Laurie Leader - RE: Valdmanis 29 Bowdoin

From: "Gary" <Gary@douston.com>
To: "Laurie Leader" <LRL@portlandmaine.gov>
Date: 4/2/2015 2:34 PM
Subject: RE: Valdmanis 29 Bowdoin
CC: <dave@douston.com>

Can you confirm the following:

PROPOSED BASEMENT FLOOR PLAN  
1/4"=1'-0"

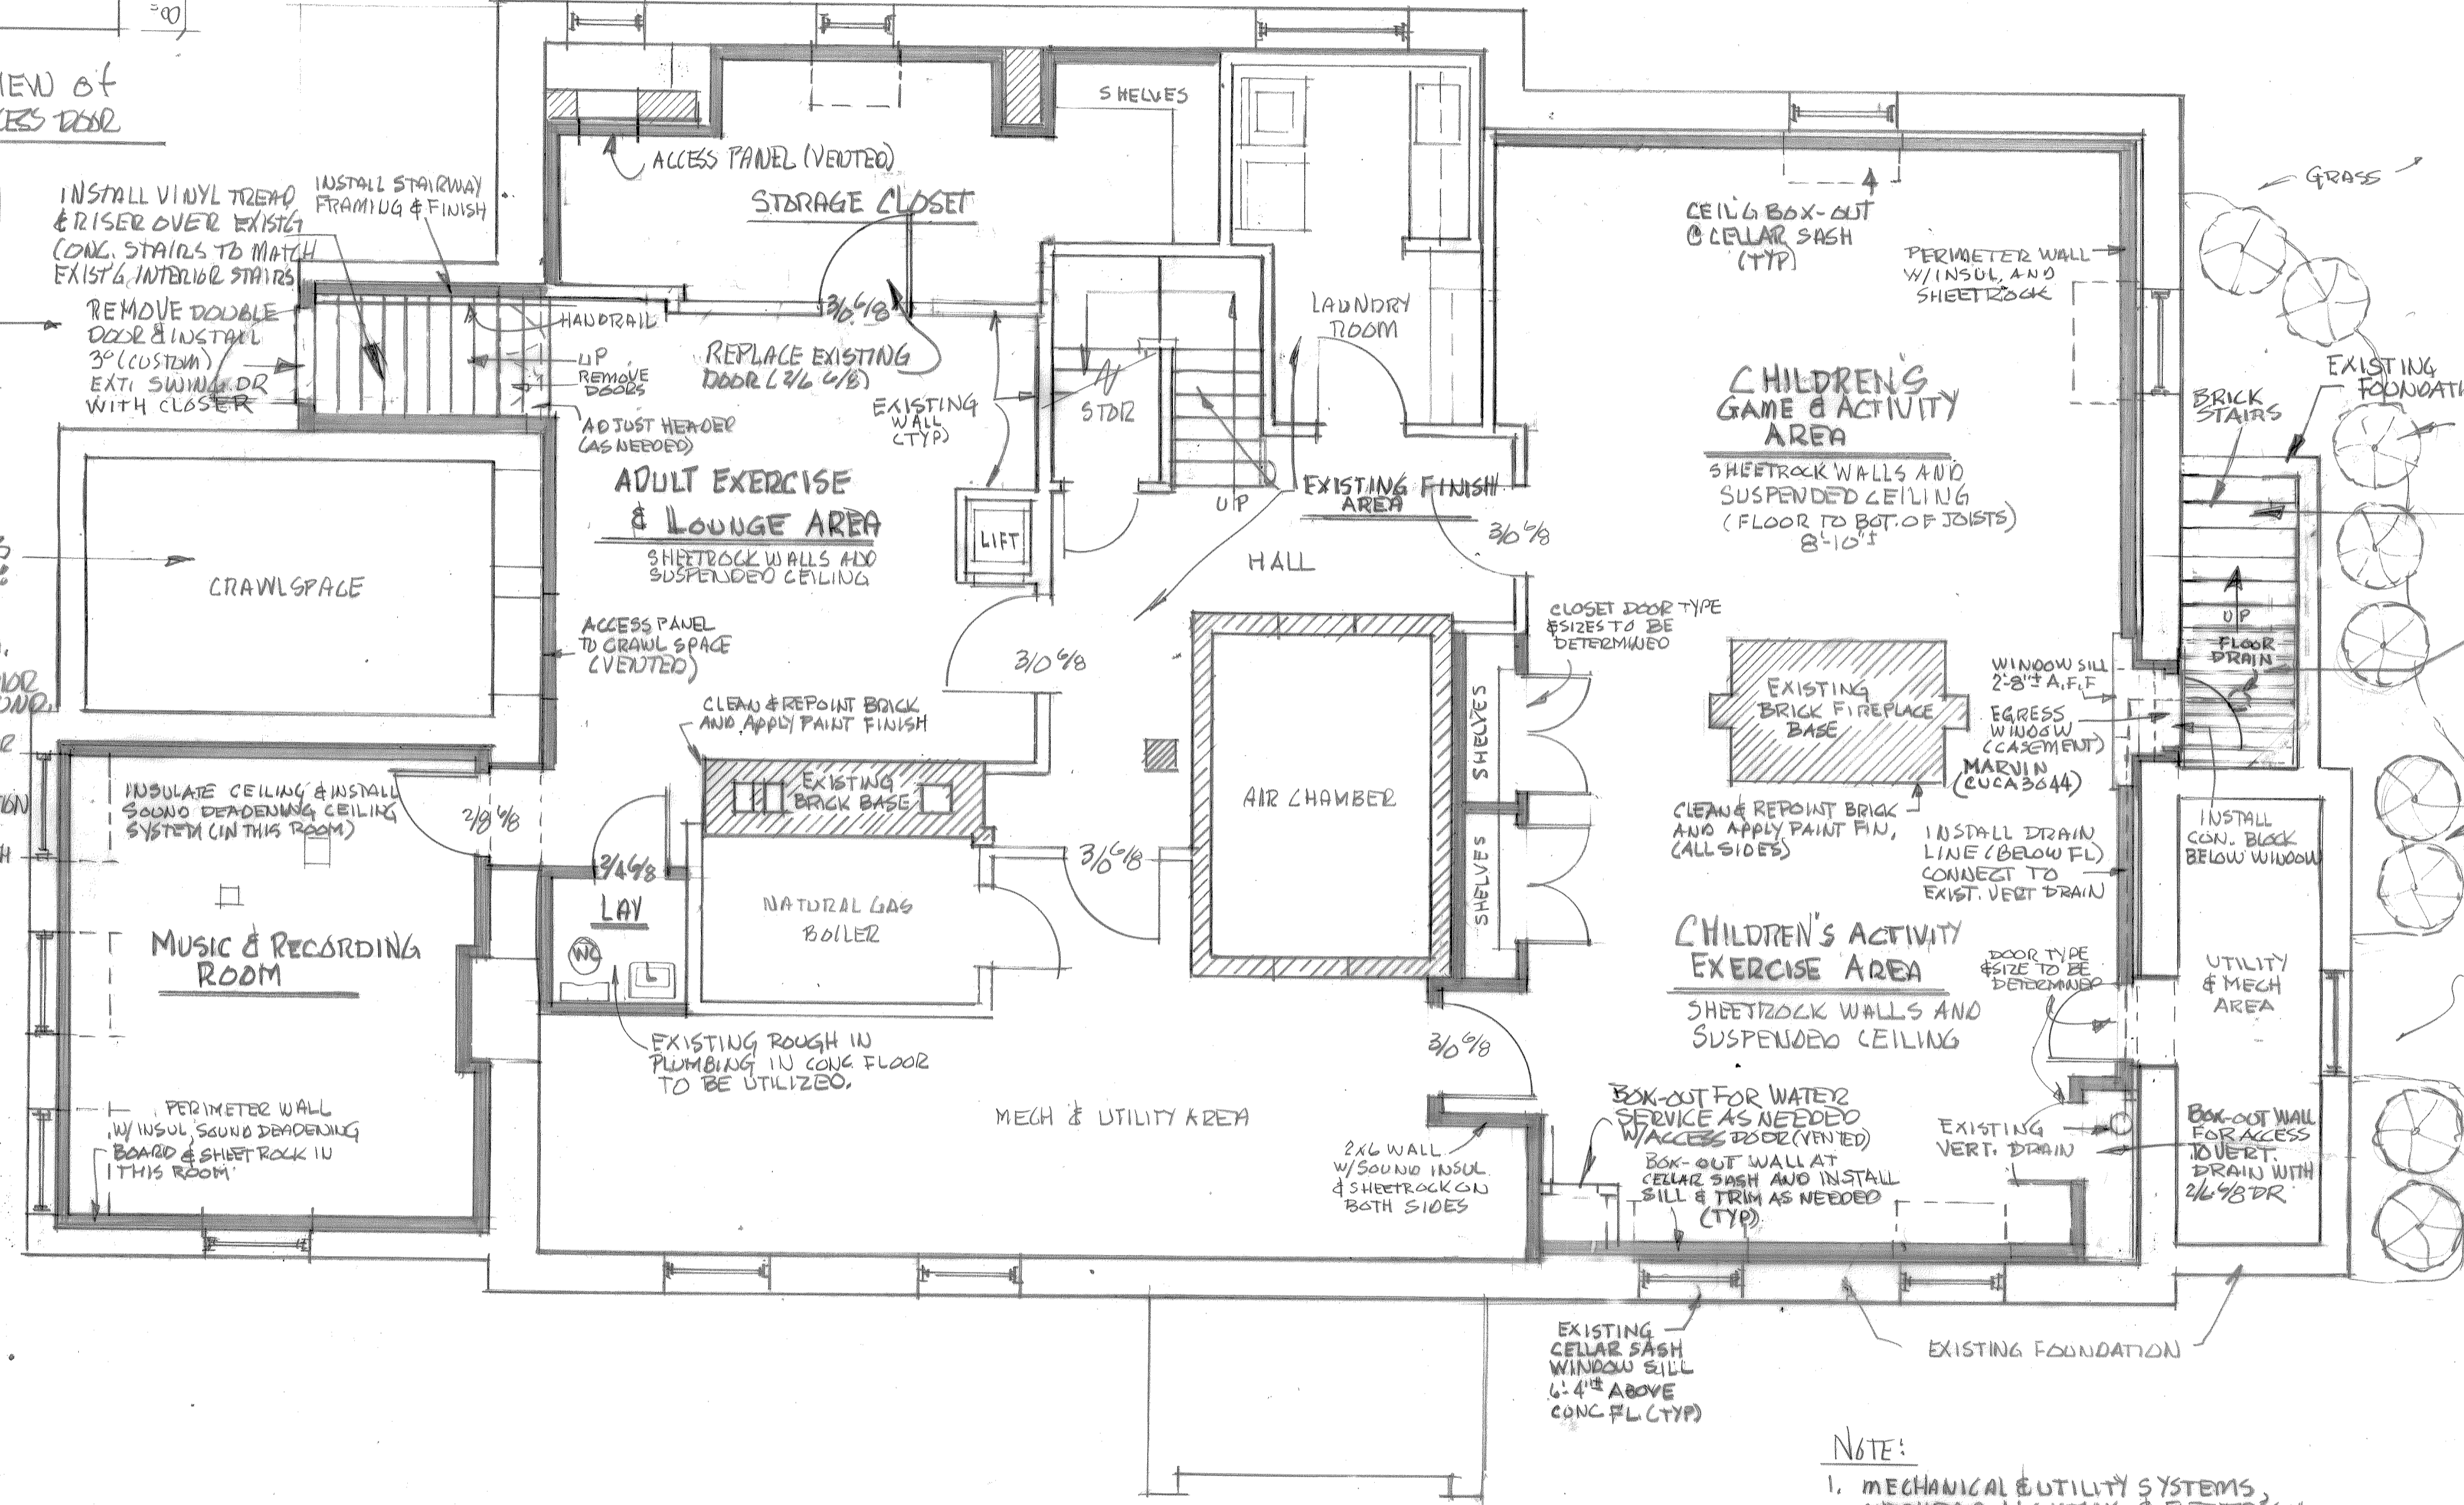
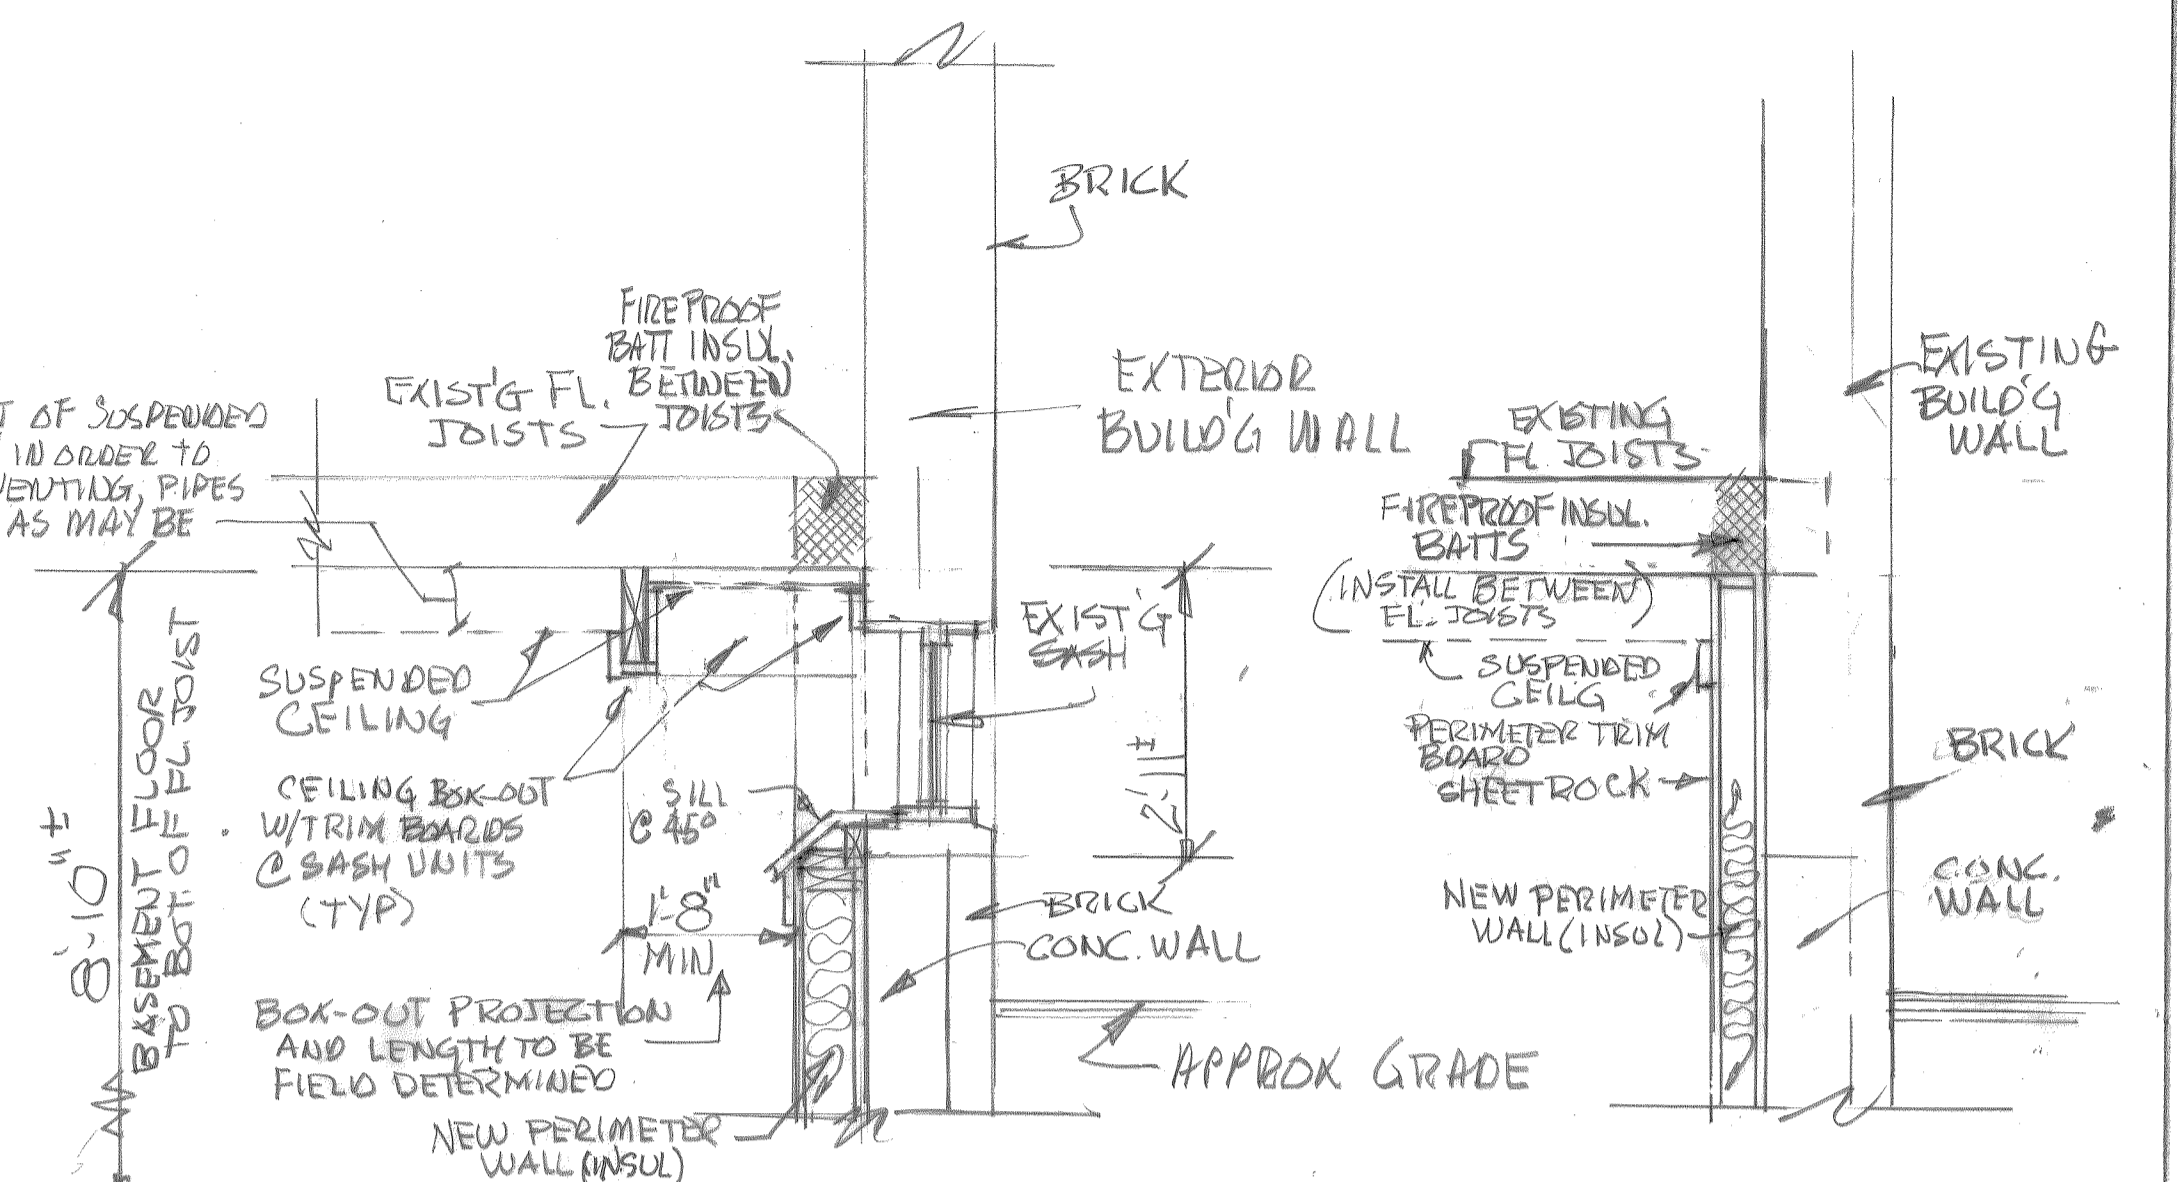
- Do the bulkhead stairs meet R311.7.9.2 Bulkhead Enclosure Stairways? **Yes – it is about 6’ 6” from the concrete floor up to the outside grade.**
- Clarify if the bathroom fixtures meet Figure R307.1 Minimum Fixture Clearances. **As drawn, it is hard to tell if all the clearance distances are met, but we will be sure to lay it out appropriately before we build.**
